**KIRKLEES METROPOLITAN COUNCIL
INVESTMENT & REGENERATION SERVICE**

**DELEGATED DECISION FOR APPLICATION FOR CERTIFICATE OF
LAWFUL DEVELOPMENT**

Reference no.: 2024/CL/92163/W

Site: Rough Lee Farm, Reddisher Road, Marsden,
Huddersfield, HD7 6NF

Existing layout plan (1:100)

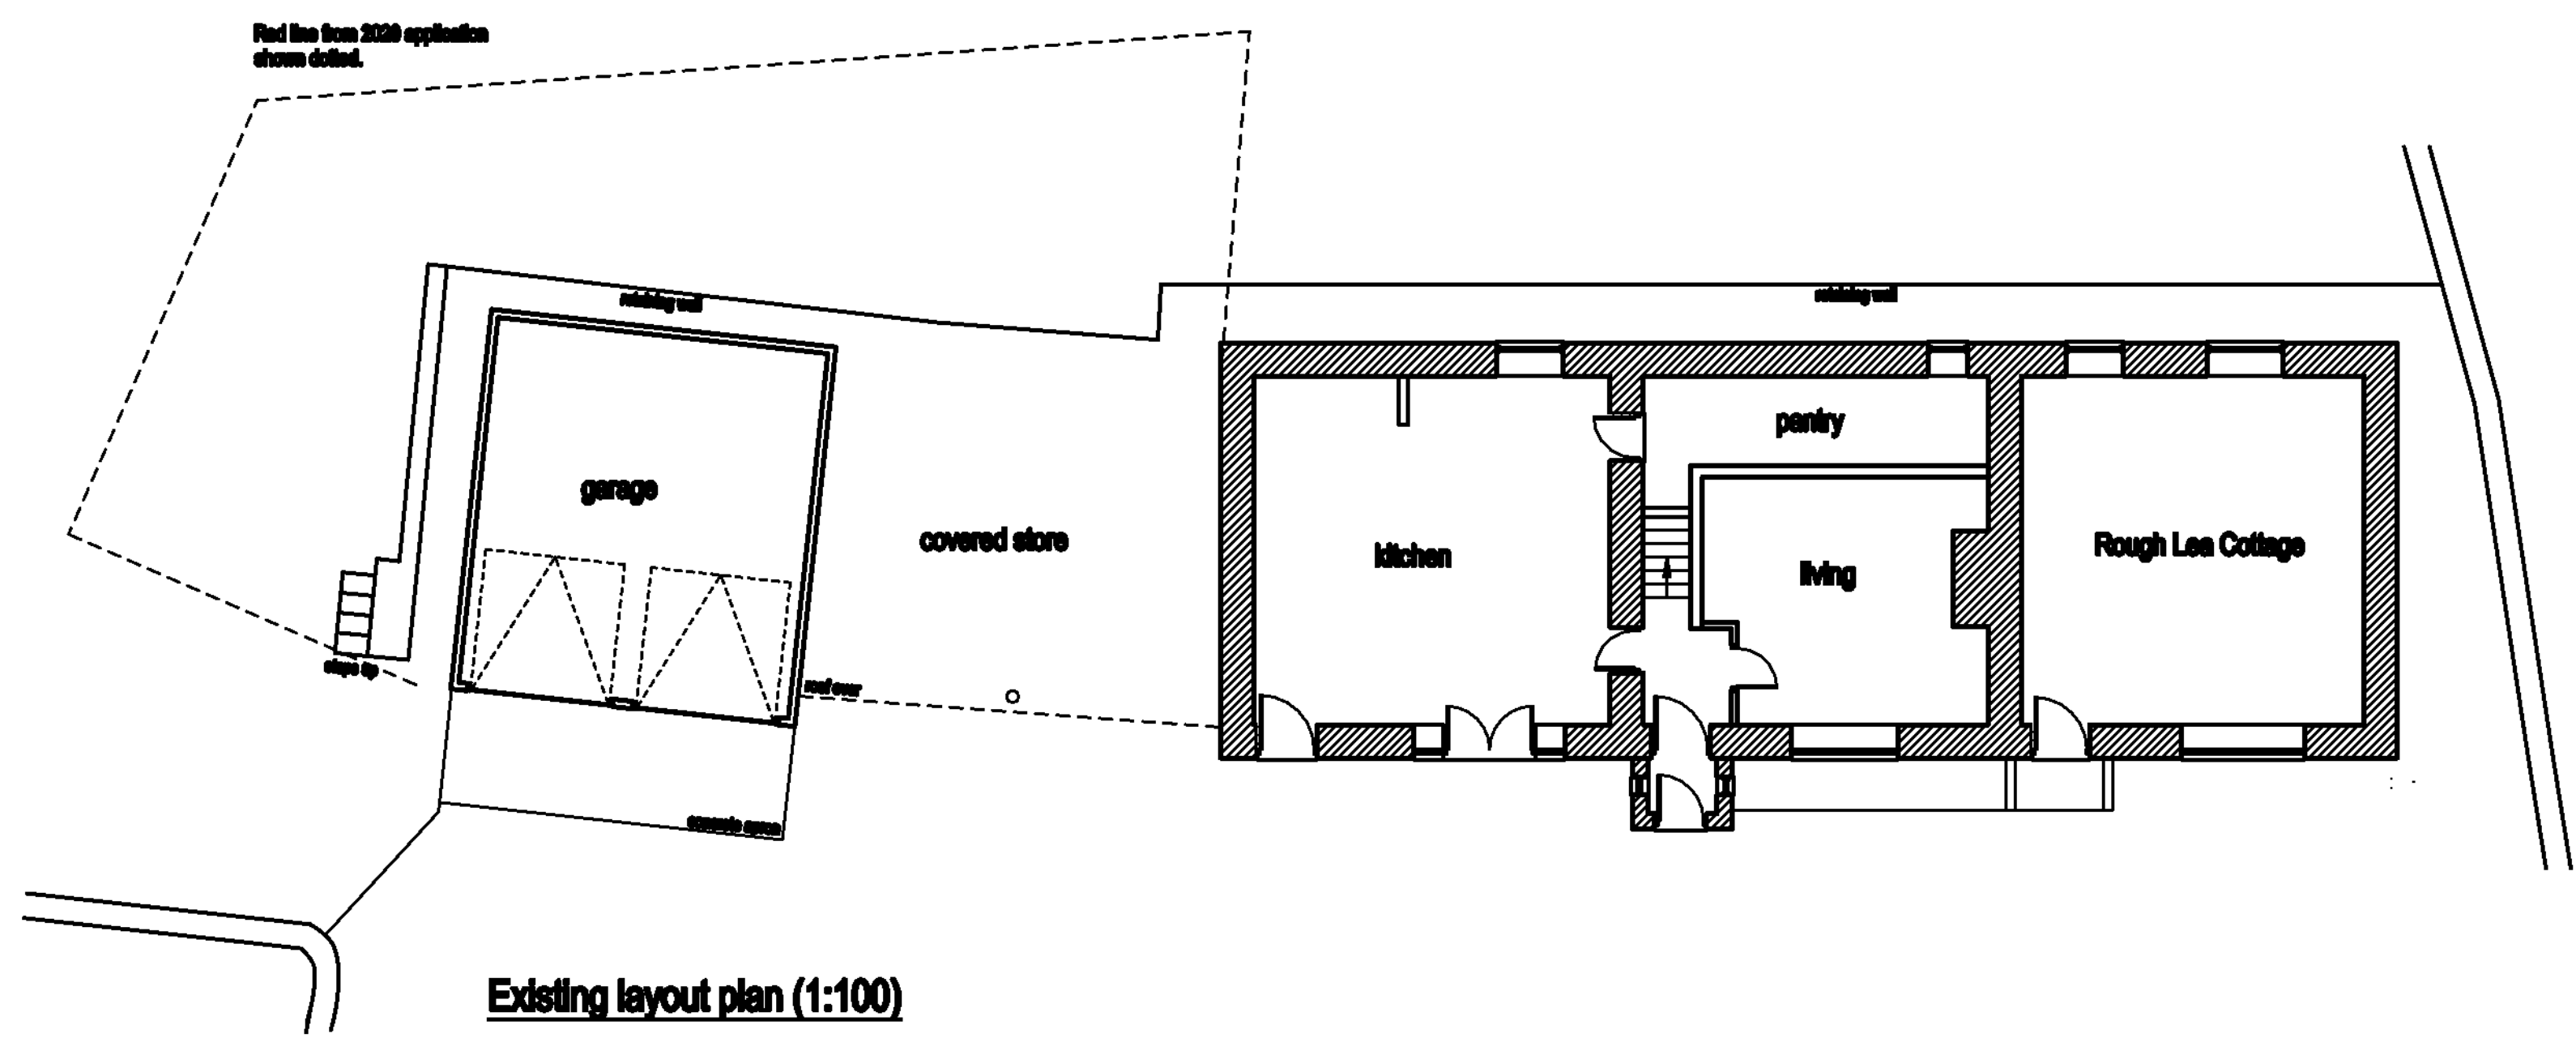
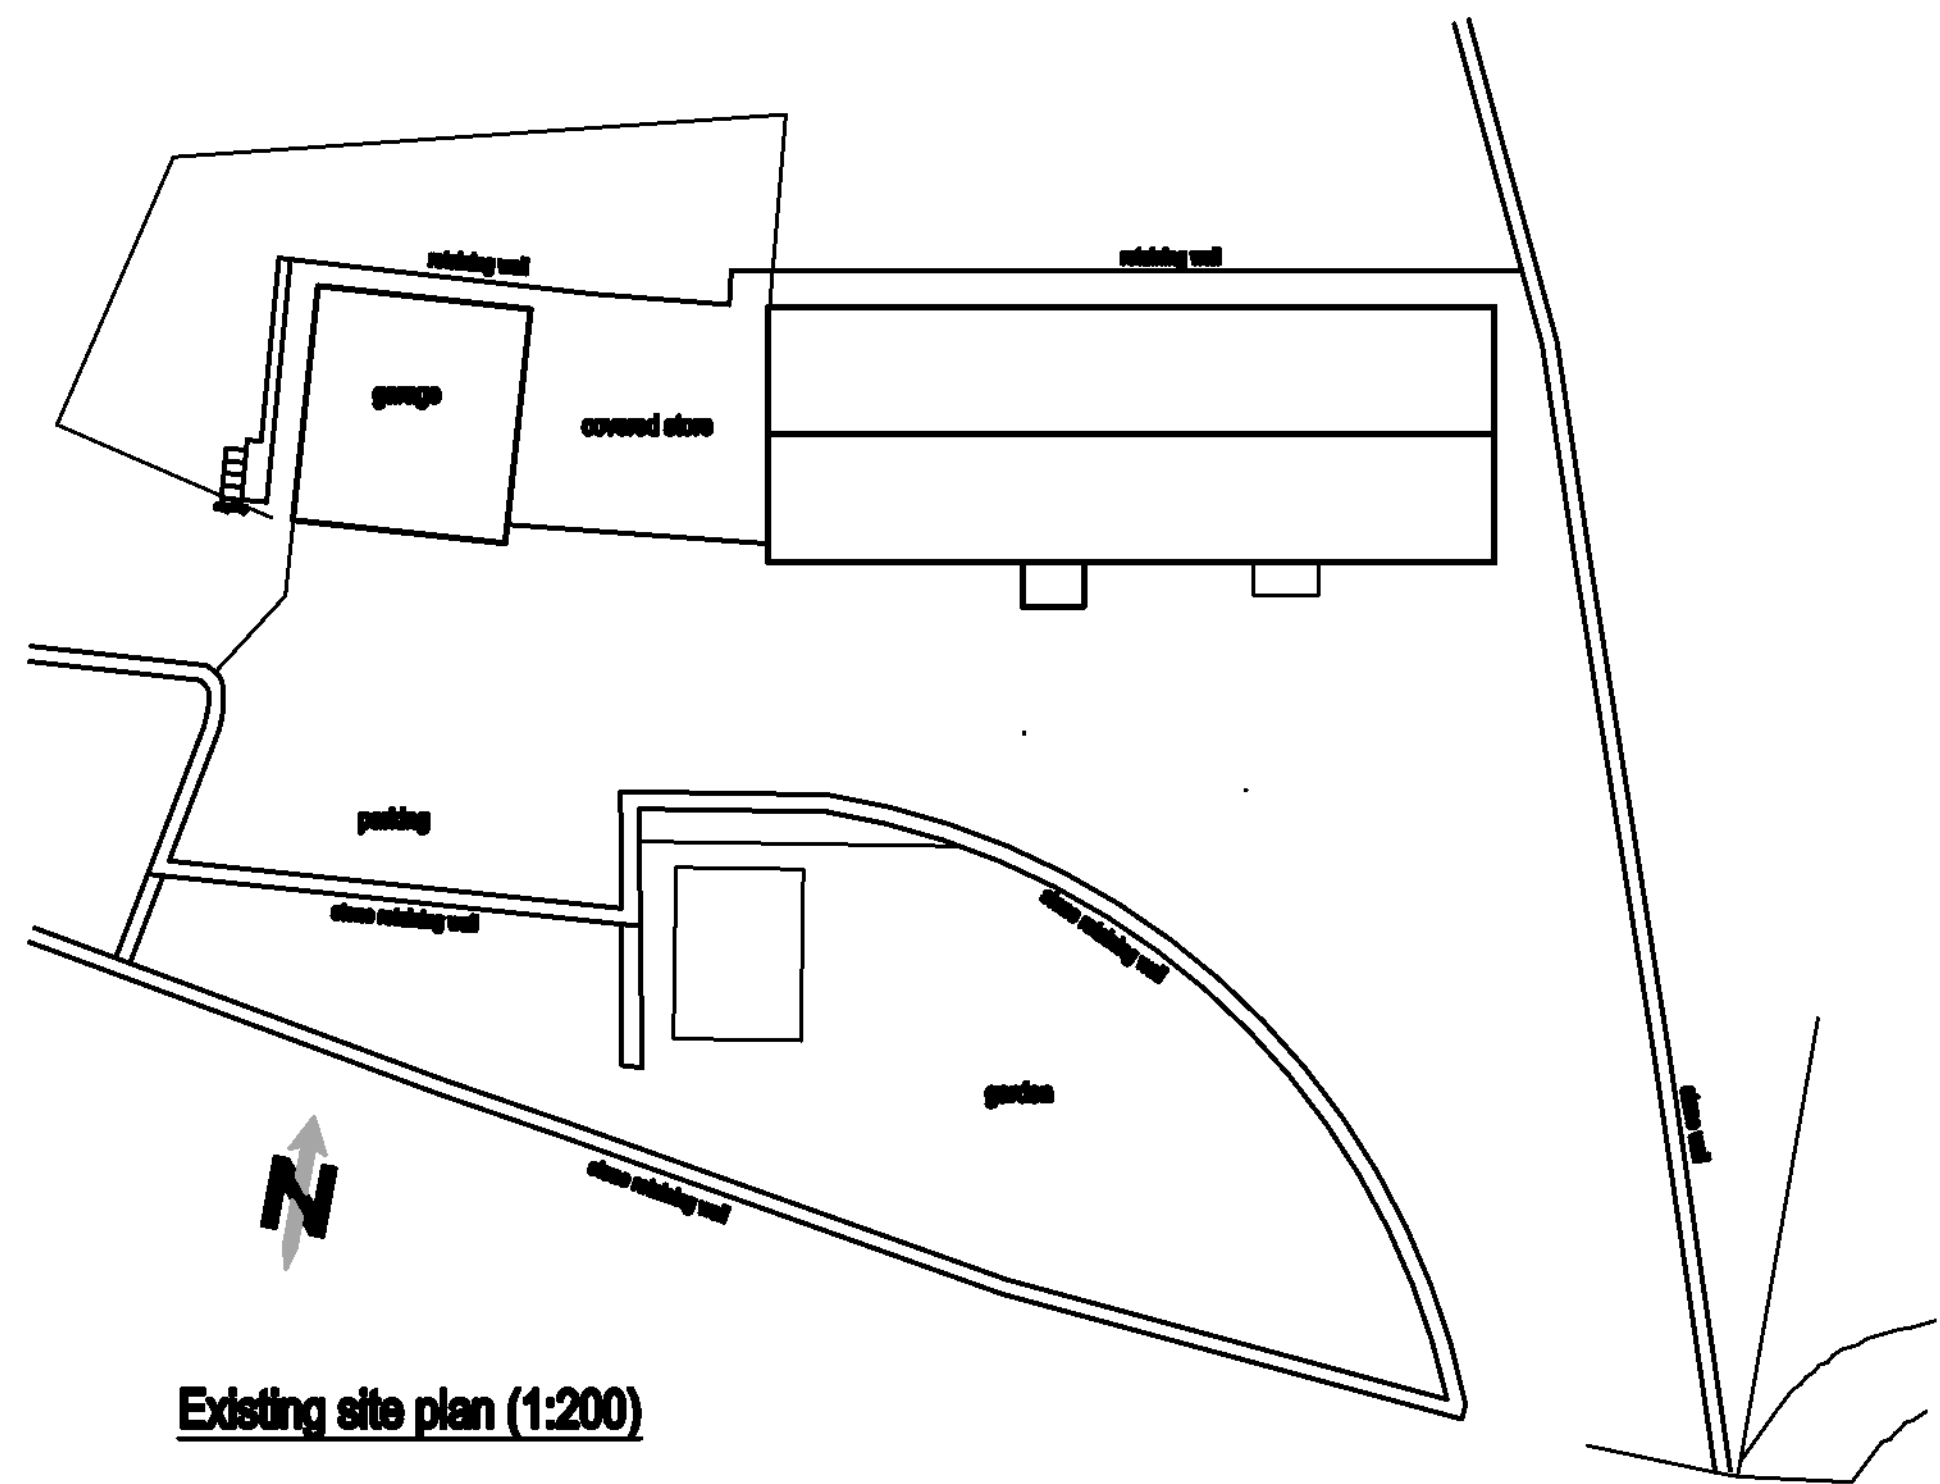
Comment: *The proposed outbuilding is shown to have a dual-pitched roof and would not exceed 4 metres in height. However, the outbuilding is considered to be located within 2m of the boundary of the curtilage and does exceed 2.5m in height.*

The applicant annotates layout plan (23 J 61 01A) with a dotted line surrounding the garage indicating this represents the red line from the 2020 application. It is assumed the applicant is suggesting this is shown to be the curtilage boundary as established by the 2020 planning application for the erection of two storey side extension and external alterations (ref: 2020/93959). The applicant also submits that a Google Earth aerial image dated June 2009 of the land to the rear of the dwellinghouse shows this land to be curtilage presumably on the grounds it appears different to the wider field. The applicant offers no further evidence to demonstrate the extent of curtilage.

With respect to the applicant's dotted annotation on the layout plan, it is well established that the redline boundary shown for the extension of the dwellinghouse does not in law formally establish the curtilage to the property.

Finally, the applicant does not argue that the gated access to the field at the south-west corner of the proposed garage adjacent to the dotted line is within the curtilage of the dwellinghouse.

The proposed garage is therefore considered to be within 2 metres of the curtilage boundary both at the rear, side and front elevations and over 4 metres in height.
